**Responses to City Review Comments Dated December 29<sup>th</sup>, 2023**  
**Cui Preliminary Short Plat**  
**SUB22 – 009**

This letter will provide responses to the city planning review comments and to the city first two Arborist review comments listed in the City's letter of review comments dated December 29<sup>th</sup>, 2023.

Date:	08 / 20 / 2023
Stamp is not valid unless signed and dated	
Job Number:	220520 - PLE - 2211
DWG Date:	08 / 20 / 2023
Sheet No.	C - 5.0
	OF
	C - 7.0

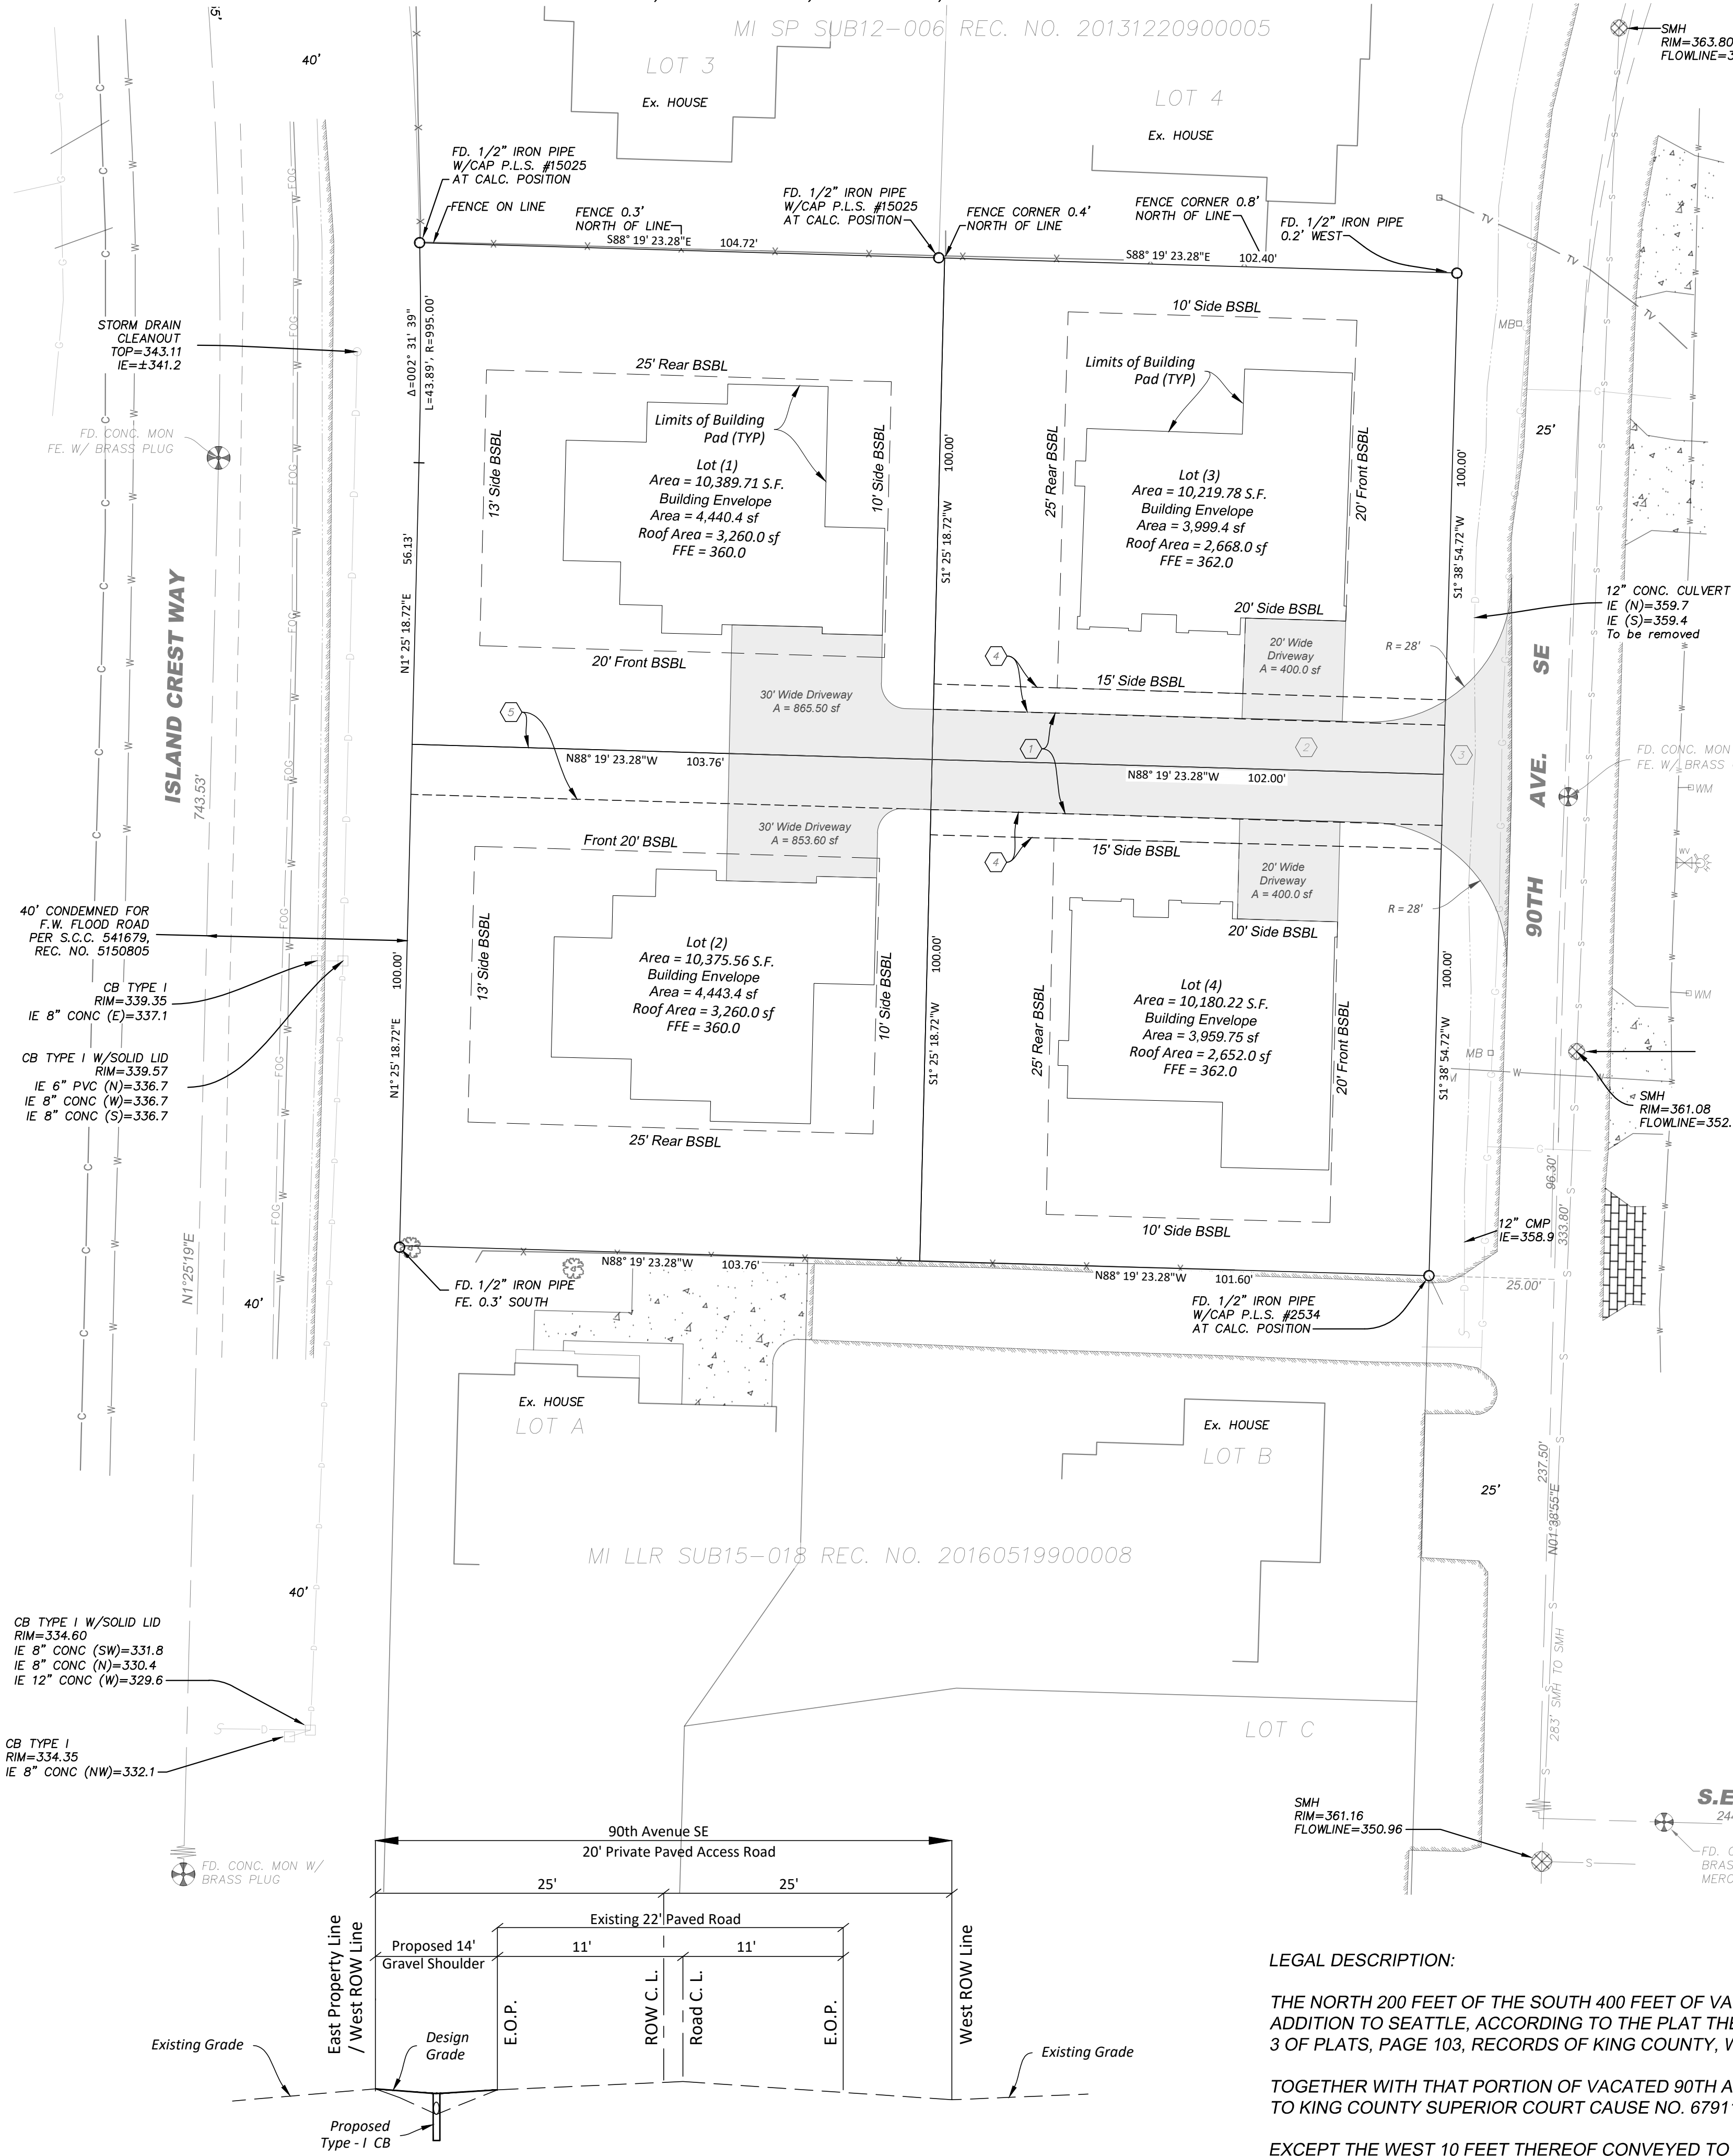
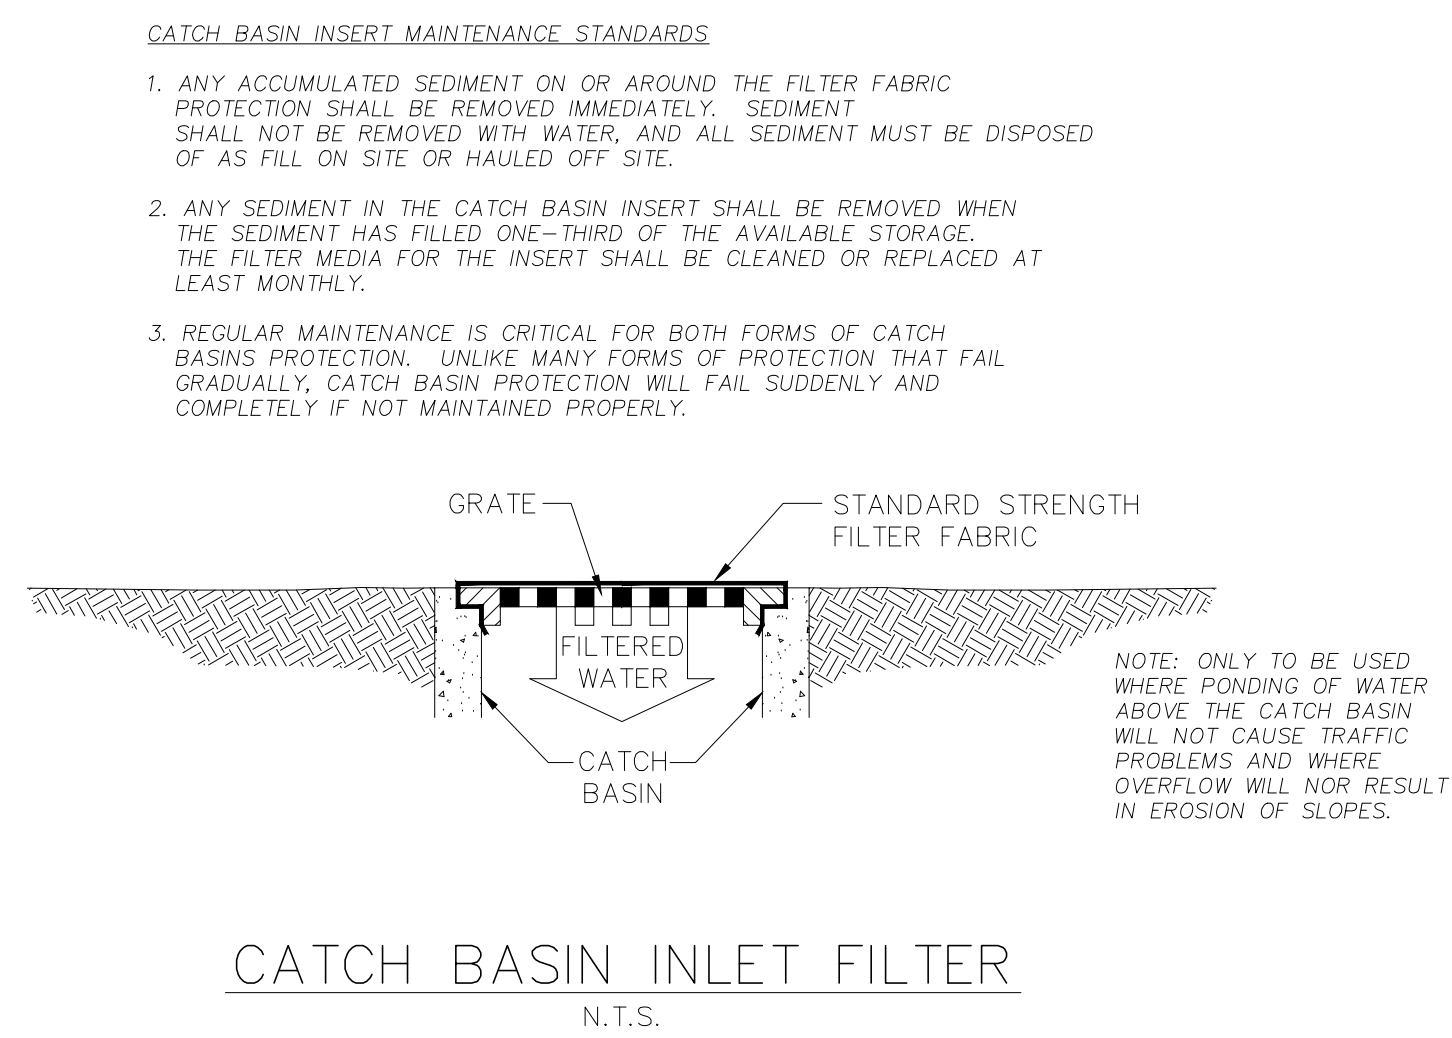
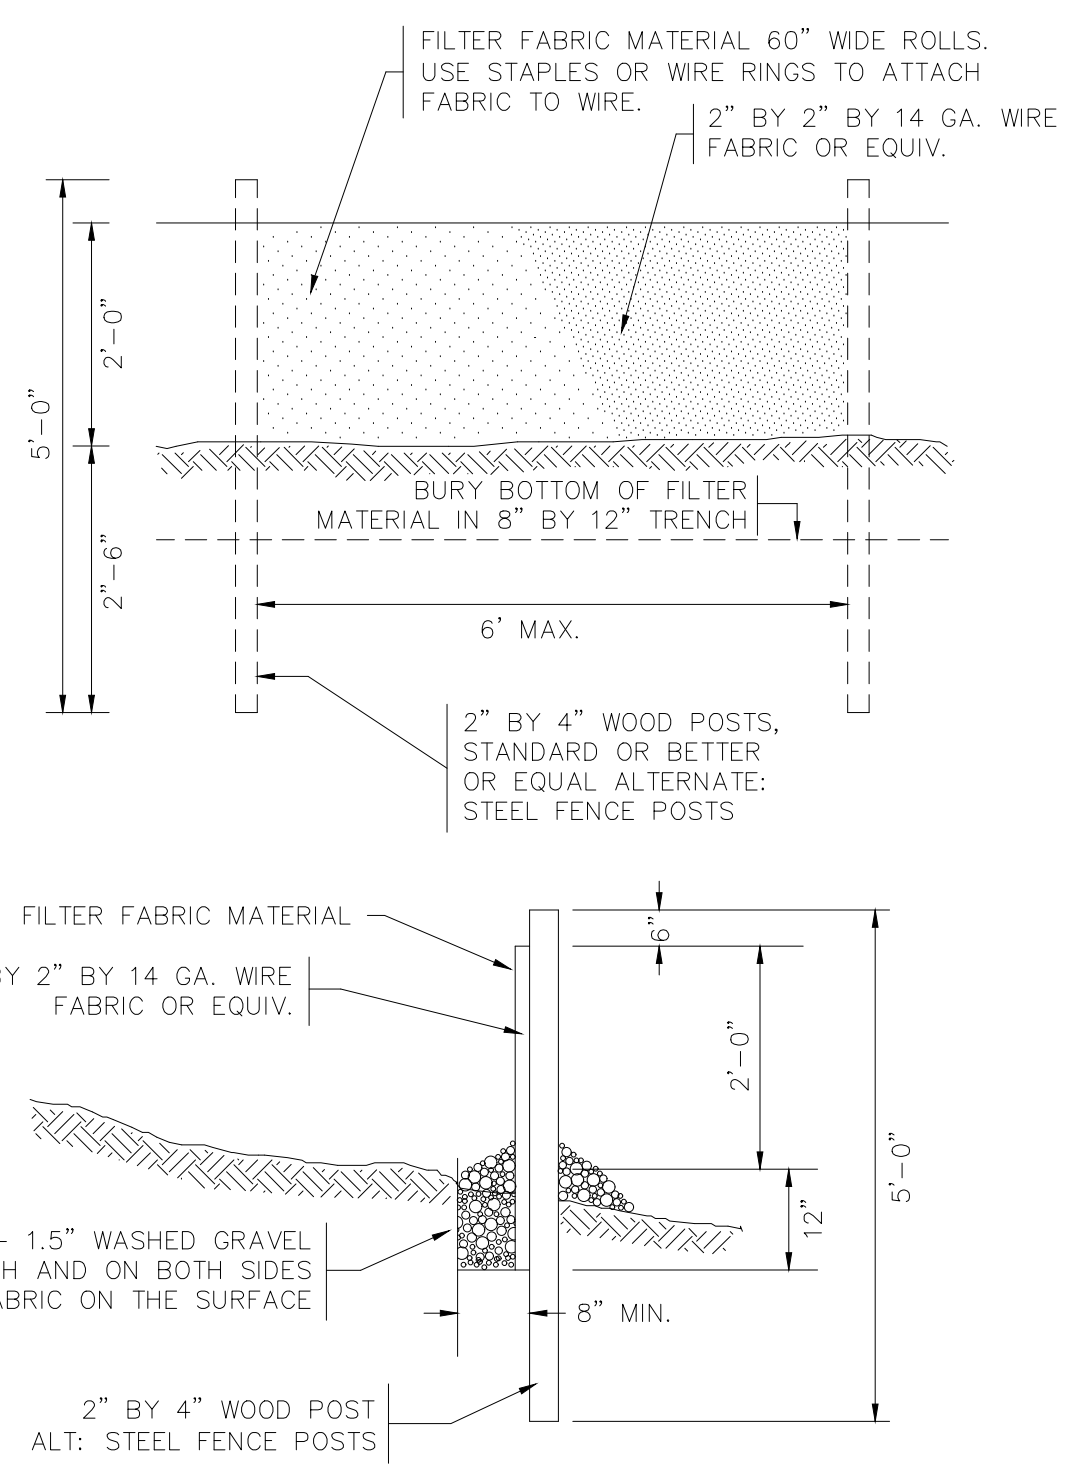
1. The intent of Civil Plan Sheet C-5.0 is to show the overall site temporary erosion and sedimentation control (TESC) devices as required by State laws, and it is not intended to show individual clearing limits / tree protection fencing around existing trees to remain. To prevent clutter of information shown and for plans clarity individual clearing limits / tree protection fencing around existing trees to be retained is shown on the Arborist Plan TR-01, please refer to that sheet for additional information.
2. To retain Exceptional Tree # 55, the building foot print on proposed lot 4 must be reduced significantly, see attached sketch of reduced foot print. This reduced footprint will result in less than 85% of allowable GFA for proposed house on proposed lot 4, and therefore, Tree # 55 cannot be retained.
